Land adj. Tern Inn, 1 Heron Way, Chipping Sodbury BS37 6XW

I write in respect of the above site, which benefits from extant planning permission from November 2022 for the erection of a convenience store with 9 no. flats above, with associated access and parking (LPA Ref: P/21/06188/F).

Following discussions with the convenience store operator, local residents and Dodington Parish Council the applicant wishes to make several minor amendments to the approved plans and documents. Accordingly, the applicant hereby applies for a minor material amendment by virtue of the provisions set out under Section 73 of the TCPA 1990.

Ground Floor 1:100

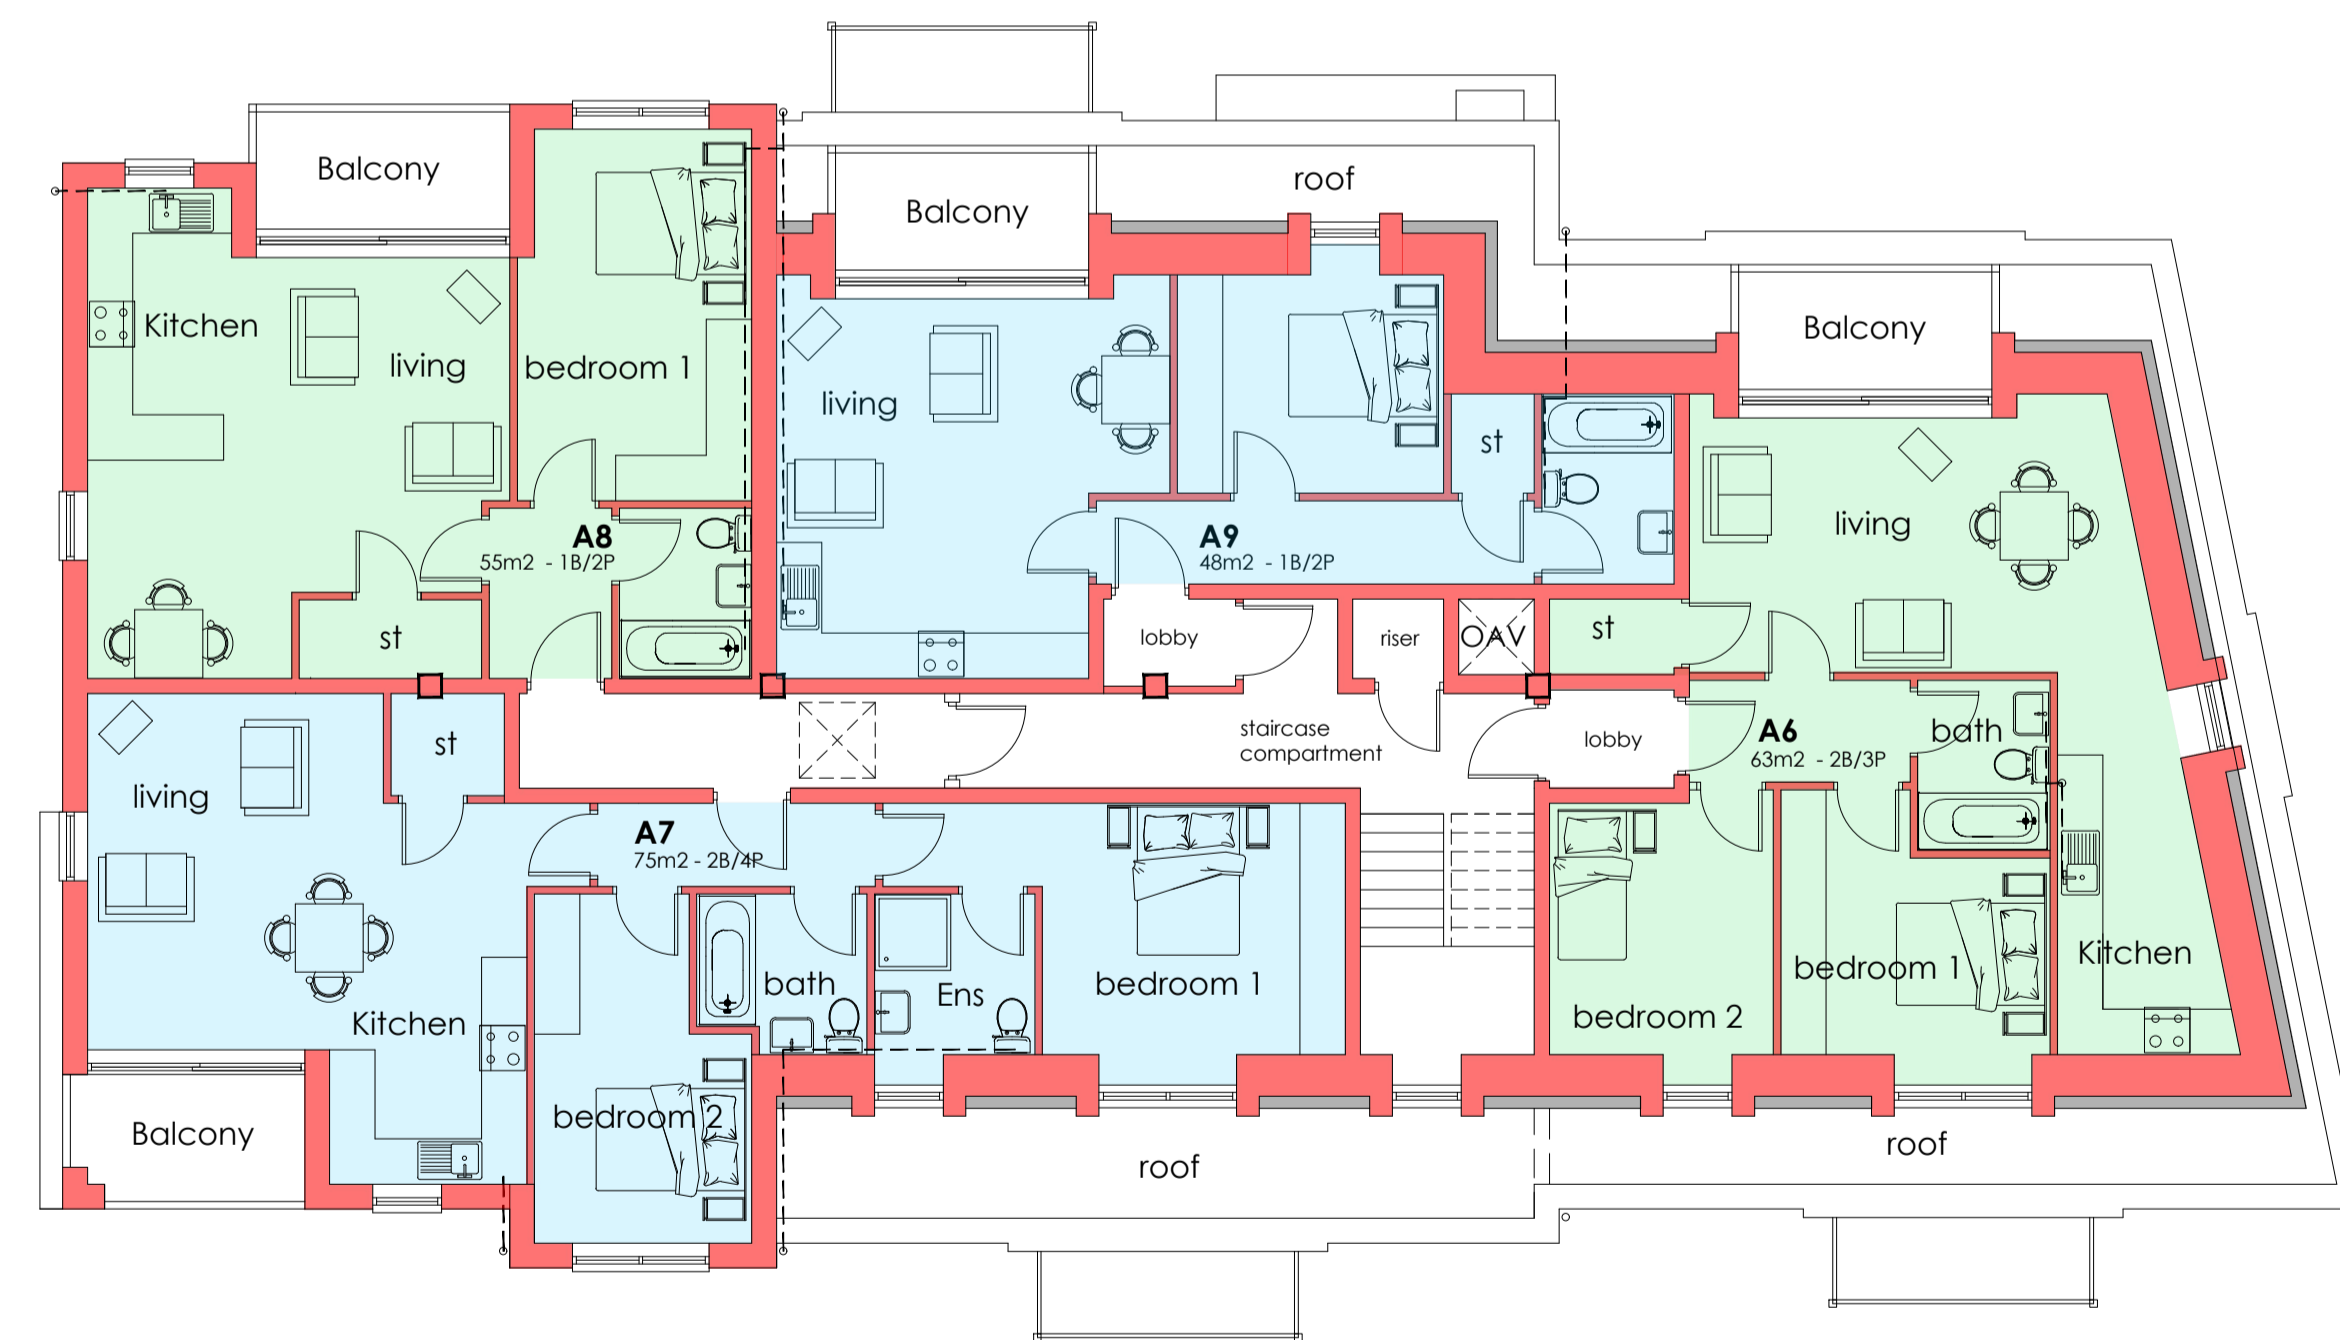
- 2. ATM** – The approved plans show an external ATM machine facing the parking area with bollards in front of it to prevent ram-raiding. The asset layout for the convenience store operator has now been finalised and they will be installing the ATM machine internally. Therefore, the planning drawings have been updated to reflect this change with the bollards now repositioned in front of the store entrance. As the external ATM has been omitted from the scheme, gas protection measures are no longer required, which means condition no 16 can be removed.
- 3. Residential windows** – The colour of the window frames for residential areas will change to RAL 7016 Anthracite.

6. **Ground Floor Commercial Windows** – The ground floor windows to the convenience store are to be removed at the request of the convenience store operator. The position of the approved windows acts to limit the placement of shelving, fridges and freezers, which would reduce the product offering of the store. To add articulation to the ground floor of building, tax windows are proposed for the former openings.
